Document DCO 7.1 / MCO 7.1

Applicant's response to the s51 / 55 advice

FEBRUARY 2026

The East Midlands Gateway Phase 2
and Highway Order 202X and The East Midlands Gateway
Rail Freight and Highway (Amendment) Order 202X

# Appendix 6d.8 – ES Link ID Locations Along B5324

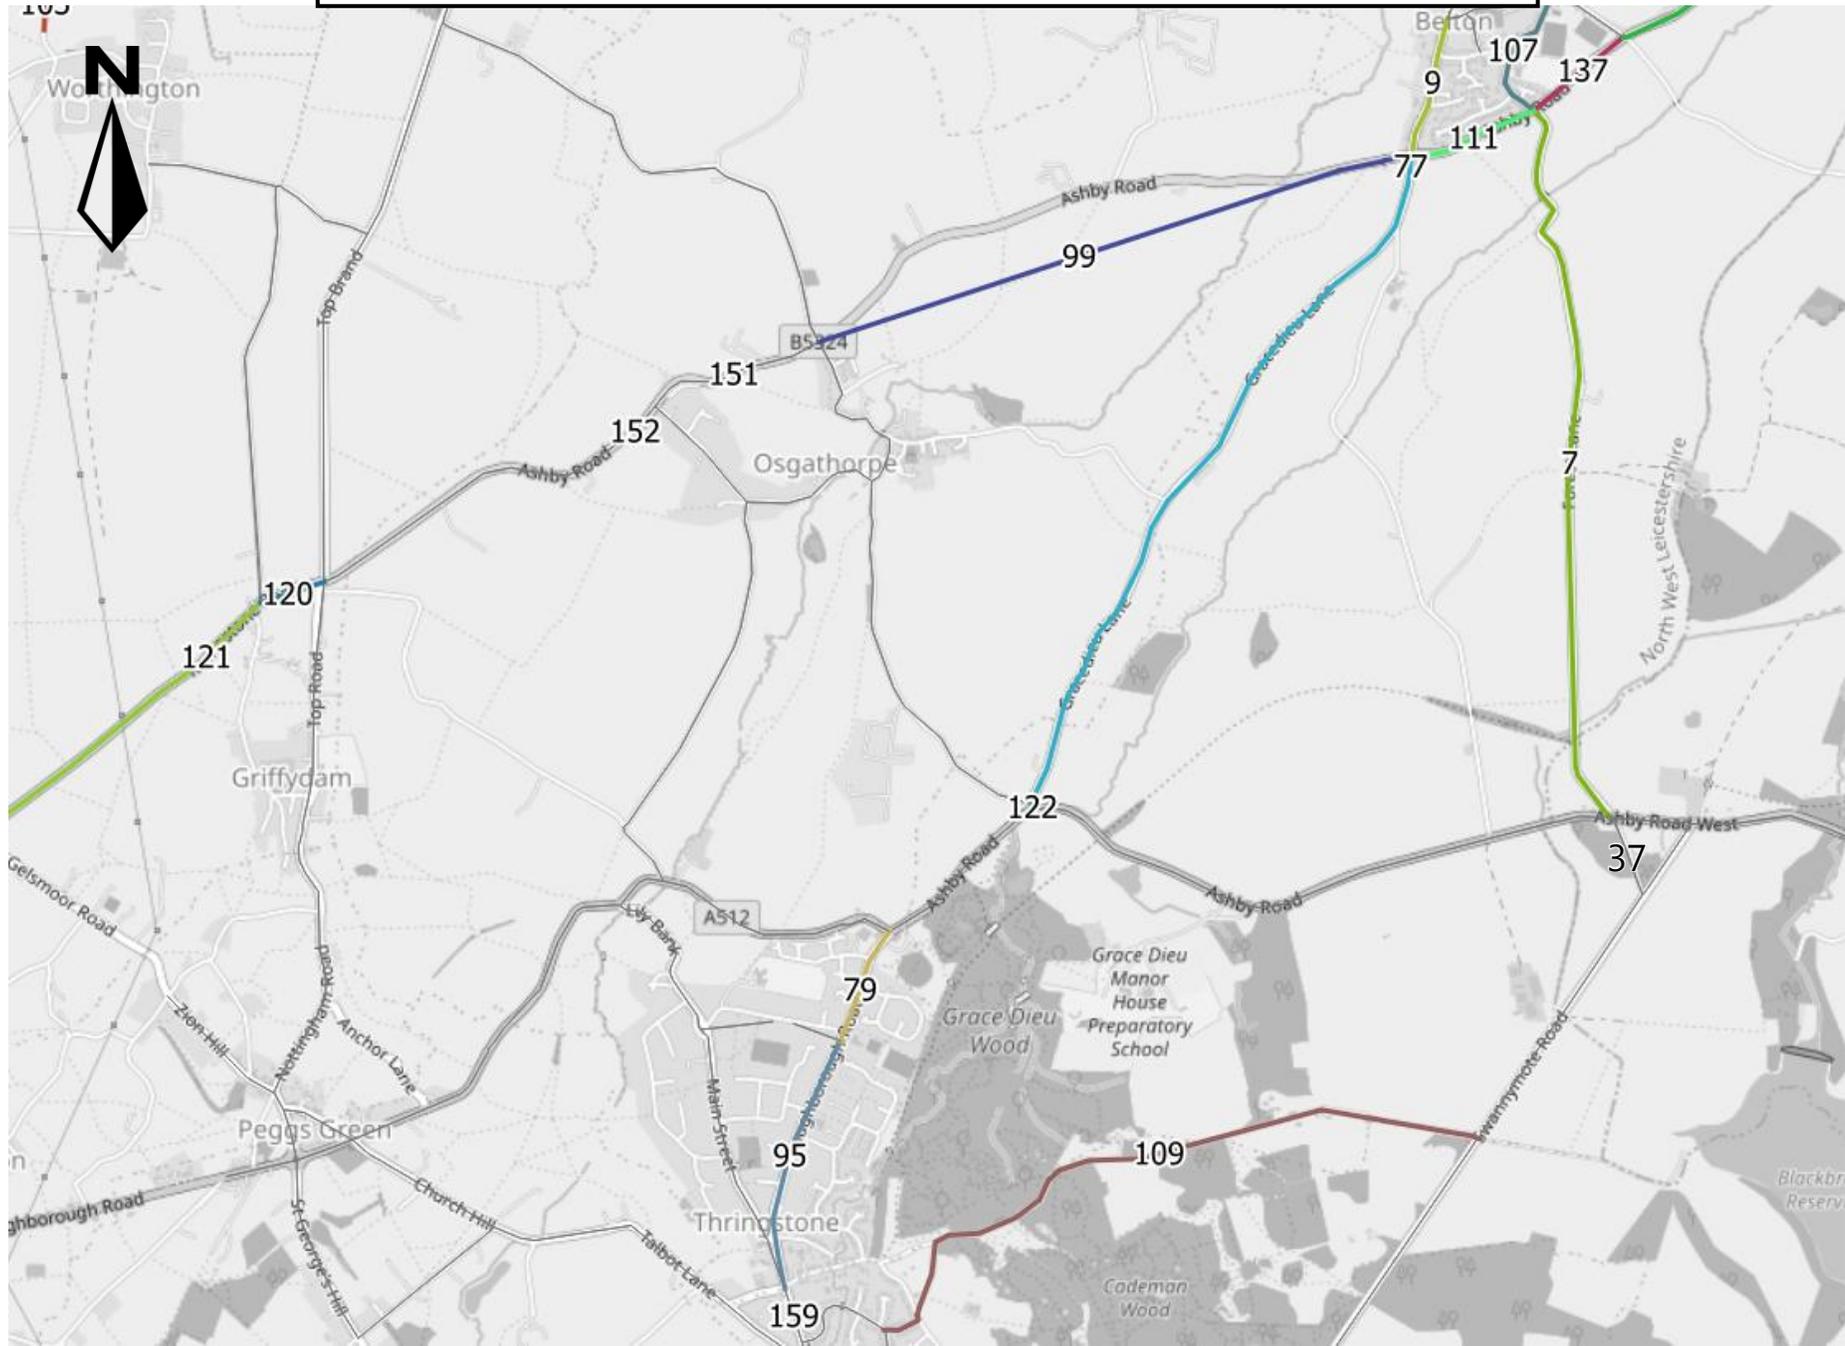
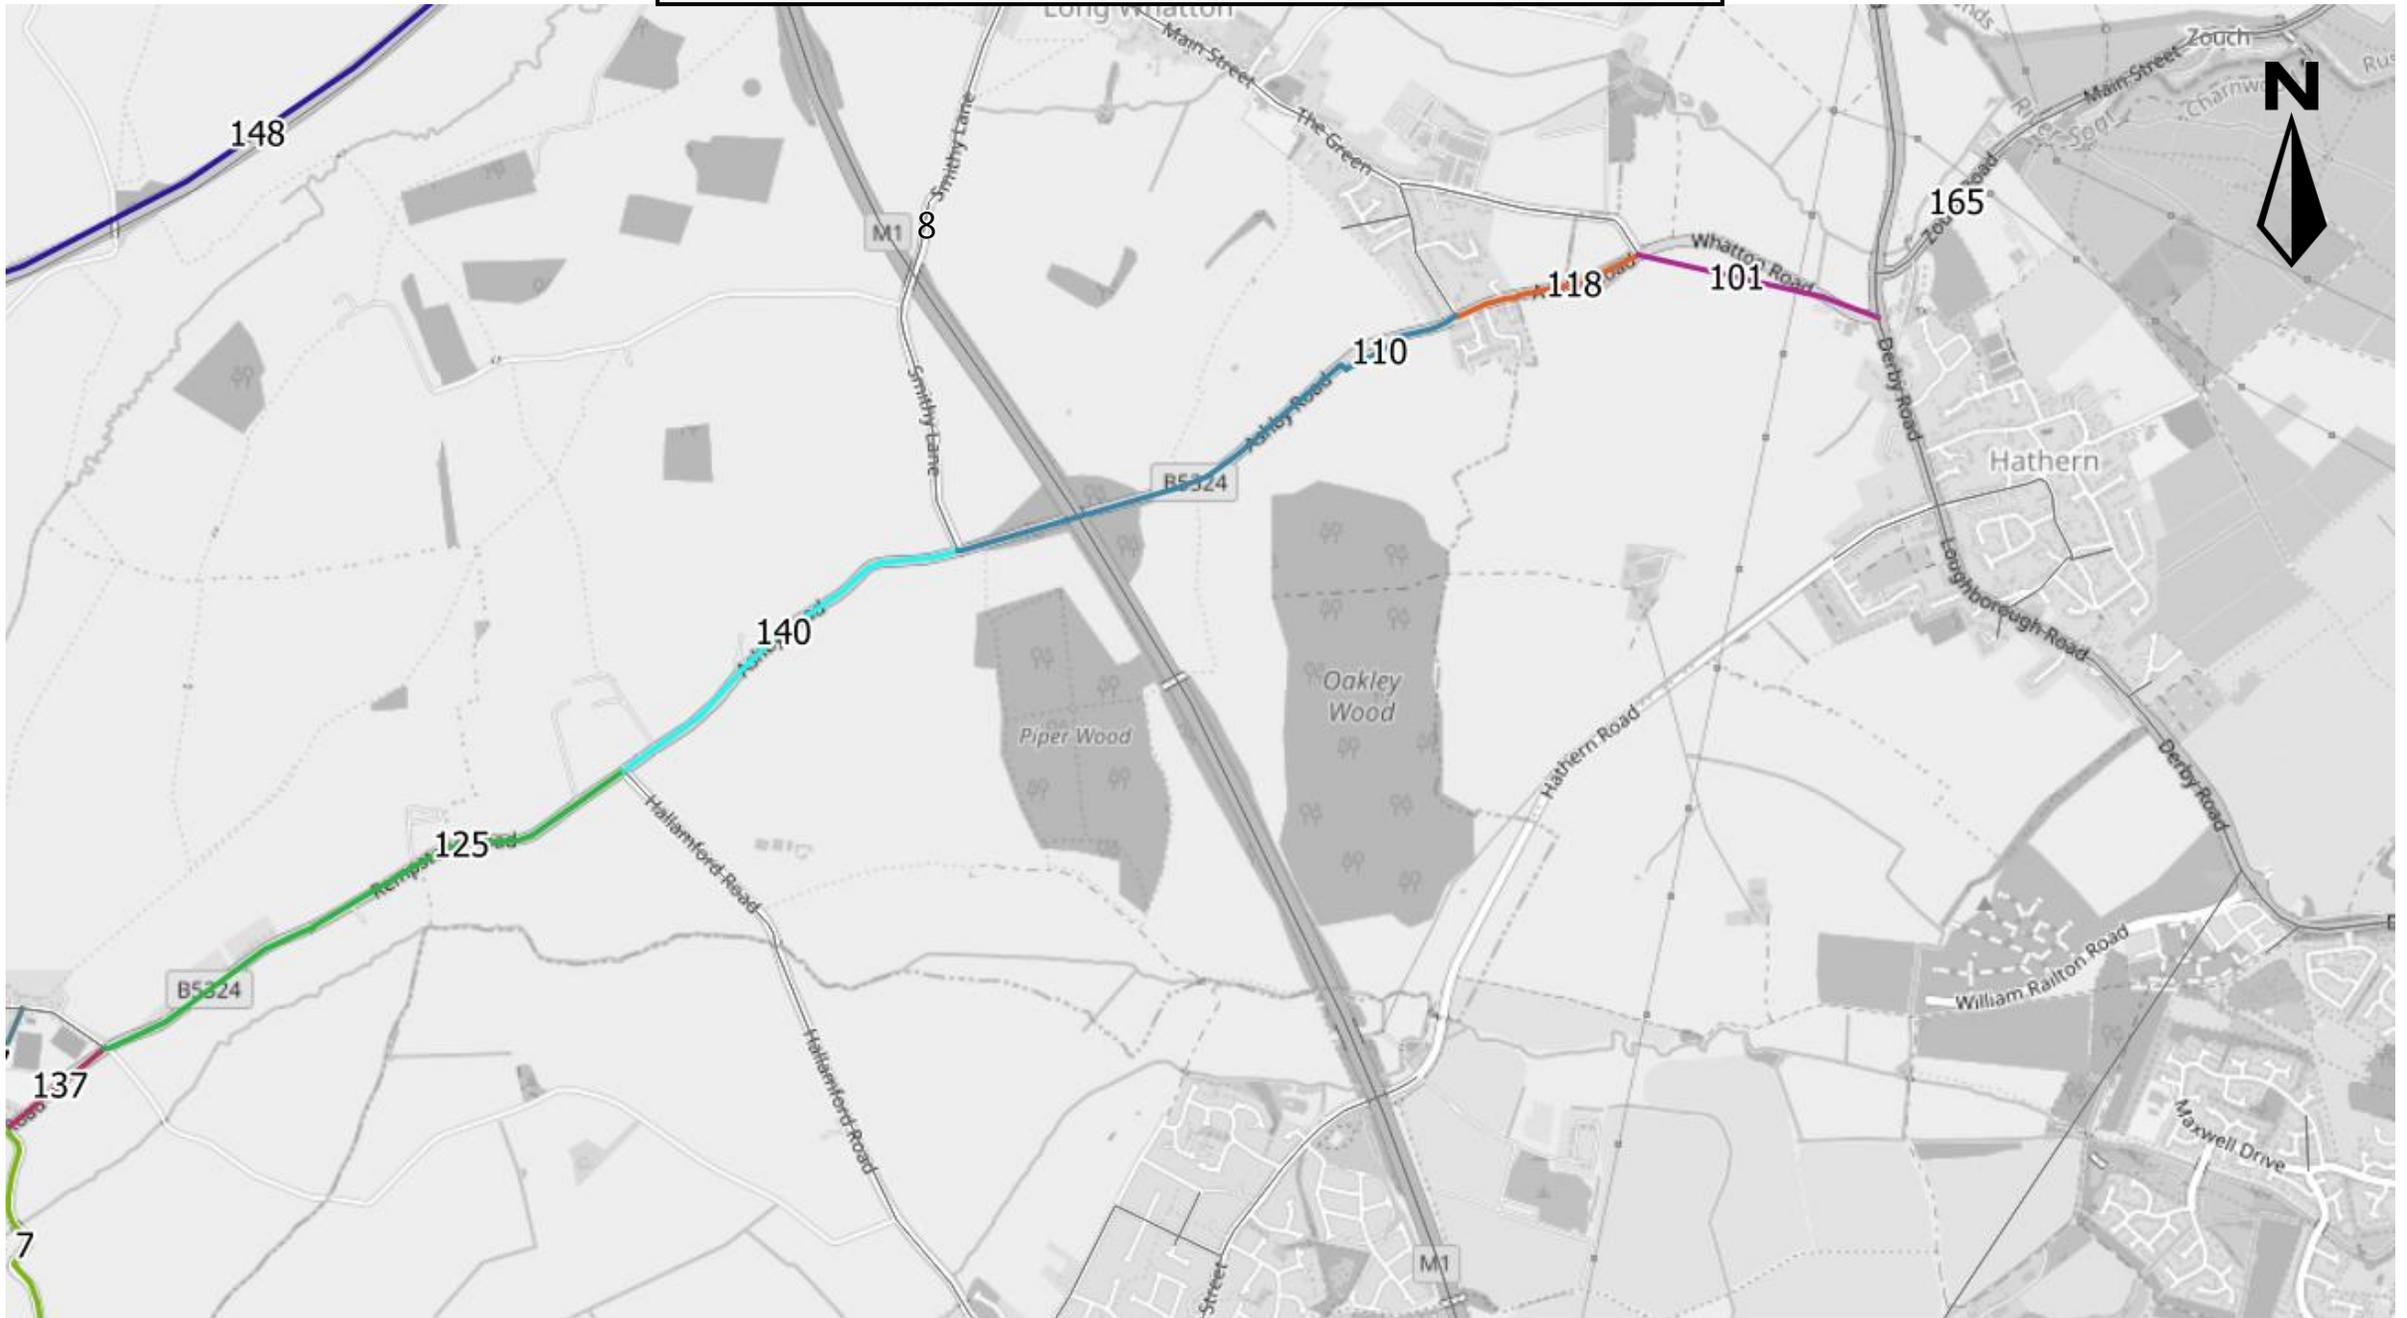
36.	i. Check and correct the description of highways links 141 and 145, described as Kegworth bypass but shown in Castle Donnington, in Chapter 6 tables 6.9 and 6.14 and Appendix 6.6D	Environmental Statement	6.6 and 6.6D	The tables in Chapter 6 and Appendix 6.6D have been corrected.

37.	ii. The links listed in the s55 comments are numbered in tables 6.9 and 6.14 but not shown at all or clearly in Appendix 6.6D	Environmental Statement	6.6 and 6.6D	Appendix 6.6D has been updated. The table at Appendix 4 lists all of the links identified and provides a cross reference to the figure depicting the relevant link.
